Appeal Decision

Appeal Ref: T2350/D/22/3290796

20 Wellbrow Drive, Longridge, Preston, PR3 3TB

- The appeal is made under section 78 of the Town and Country Planning Act 1990 against a refusal to grant planning permission.
 - The appeal is made by Mr T Howson against the decision of Ribble Valley Borough Council.
 - The application Ref 3/21/0969, dated 22 September 2021, was refused by notice dated 9 November 2021.
 - The development proposed is replacement front porch and dormer to front.
-

## PART FIRST FLOOR / LOFT PLAN

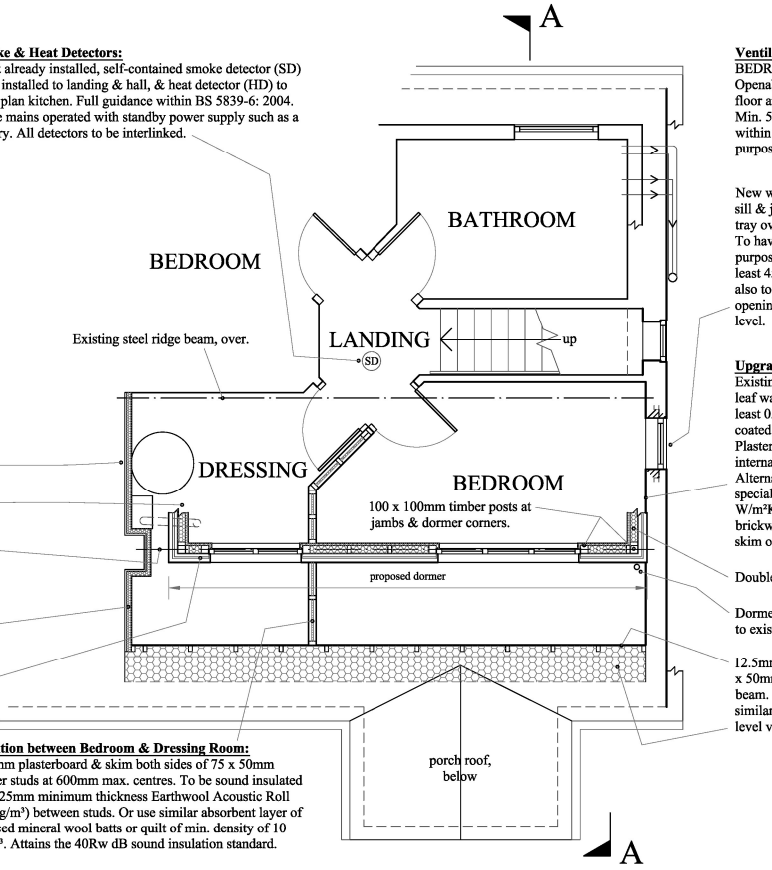
4. The proposal is to replace an existing entrance porch on the ground floor and construct a front-facing dormer. The Council does not object to the replacement porch, but considers the dormer to be incongruous and conspicuous, because of its width and overall size. With regard to the porch, I agree with the Council's assessment that it would be acceptable in terms of its impact on the character and appearance of the area.

6. Although the proposed dormer would be clearly visible on the front of the property, it would not appear overly dominant, because it would be set well-above the eaves level at the front of the dwelling. Much of the existing roof slope would remain and I consider that the structure would be a subservient addition to the property. The use of matching external materials would also ensure that its visual impact would be reduced. I accept that the proposal would result in the dwelling appearing different from the adjoining property, but given the modest scale of the dormer, I am not persuaded that this would be unacceptably harmful.

7. Therefore, I consider that the proposal would not have an adverse effect on the character and appearance of the existing dwelling or on the streetscene. Consequently, it would not conflict with either the Development Plan or The Framework, as referred to above.
